**Response to Notification of Request for SEAR's: SSD-17552047 – 155 - 217
Aldington Road, Kemps Creek**

Pre-lodgement Advice

Proposed Development State Significant Development - Warehouse & Logistics Hub

Nos. 155-167 Aldington Road KEMPS CREEK NSW 2178

Figure 6: Trunk Drainage Infrastructure identified in the Draft Mamre Road Precinct DCP

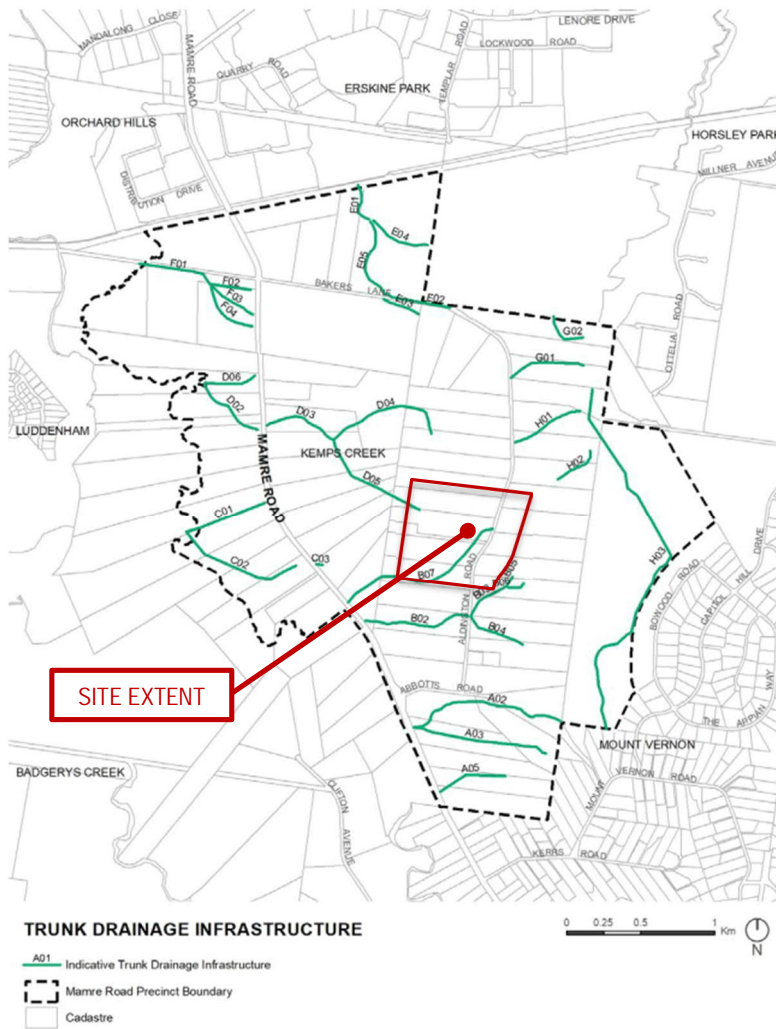
- The application is to demonstrate how stormwater discharge from the proposed development complies with the trunk drainage infrastructure as per Figure 6 of the Mamre Road Precinct Draft DCP. The application shall include concept stormwater plans for both the proposed development and the ultimate developed estate scenarios.

Figure 4: Proposed Estate Plan

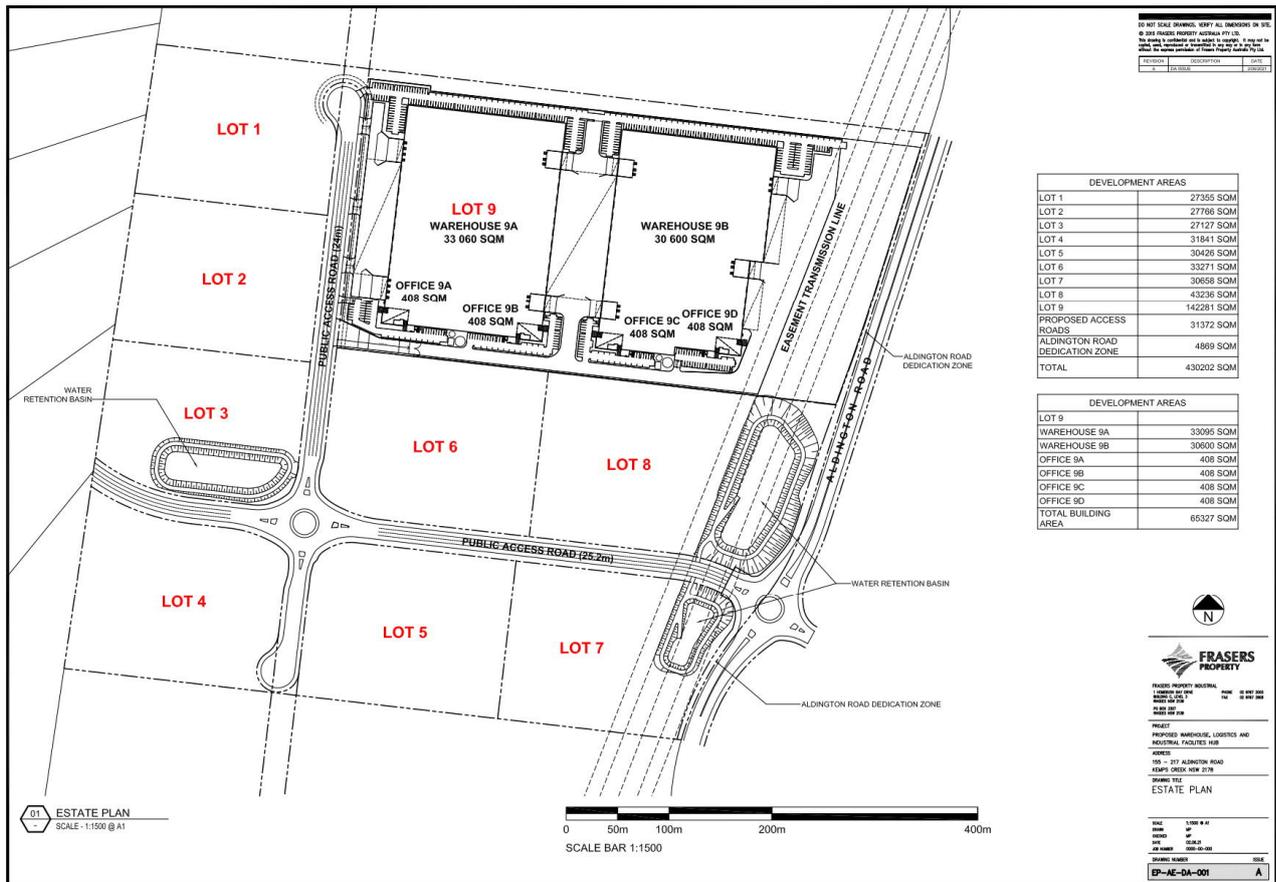
- Of positive note, is the indication of 7.5m wide landscaping between the proposed internal access road and subdivision lot boundary for the proposed built form on Lot 9. Council has advocated with the Department that the Draft DCP provision is inadequate and incapable of achieving the objectives of the standard, given the expanse of hard stand areas proposed to support large scale industrial warehouse developments. The concept plan for Lot 9 does have some parking encroachments forward of the 7.5m setback line (adjacent to entry / exit driveways). It is considered appropriate that a consistent setback be adopted and that the minor encroachments be removed or at a minimum, the 2 x spaces entirely forward of the setback line be deleted.

- While Lot 9 has a suitable and respectful setback zone to the proposed internal road for landscaping, diagrammatical indications of significantly lesser front setbacks to the south of Lot 9 and opposite Lot 9 are not supportable

and undermine the intention of the standard for consistent embellished streetscape presentations. Maintenance of a consistent setback zone is critical between lots for the entire road length.

- Motor vehicle access for the south-eastern car park for Warehouse 9A and the southern car park for Warehouse 9B relies upon the shared use of a heavy vehicle access driveway off the internal estate road which is not supported. Car parking areas between the warehouses appears to be shared with heavy vehicle manoeuvring areas and is also not supported. Car parking areas along with pedestrian and vehicular access to all car parking areas shall be separated from heavy vehicle access and heavy vehicle manoeuvring areas for safety reasons.

- The proposed subdivision arrangement and indicated internal road network is inconsistent with the structure plan within the draft DCP and cannot be supported unless the NSW Government confirms acceptance and amends the road network structure plan in the Draft DCP. The proposal will need to respond to a setback alignment for the Addington Road reconstruction which has not been resolved and designed. Reliance on the existing easement extent in isolation is inadequate.
